**From:** Nicholas Scott [REDACTED]  
**Sent:** 18 February 2022 11:25  
**To:** Simon Davis <[Simon.Davis@arun.gov.uk](mailto:Simon.Davis@arun.gov.uk)>  
**Subject:** RE: Y/19/22/DOC Approval of details condition 4 under Y/89/14/PL ref PRow (FP200/2)

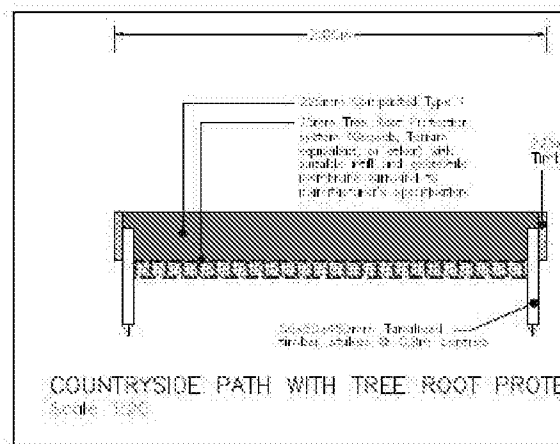
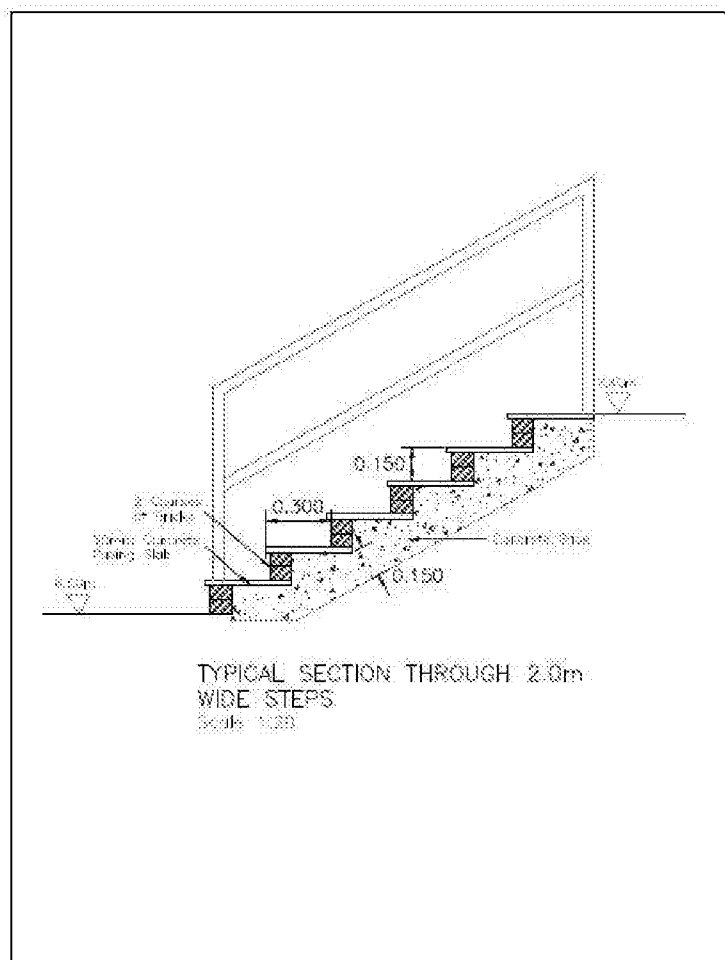
This additional information is helpful and in main does satisfy my query and provides the information I require. The only change I would suggest would be the specification for the surfacing of Countryside footpath and I see reference to eco-mix. Due to issues with this surface in the past we have now moved away from this material and attached is a standard specification for a footpath and the most appropriate surface would be Option B in the "FOOTPATH - Alternative Construction Types". If the document could be changed to reflect this then I have no objection the proposals and the additional information request is considered satisfied from my perspective.
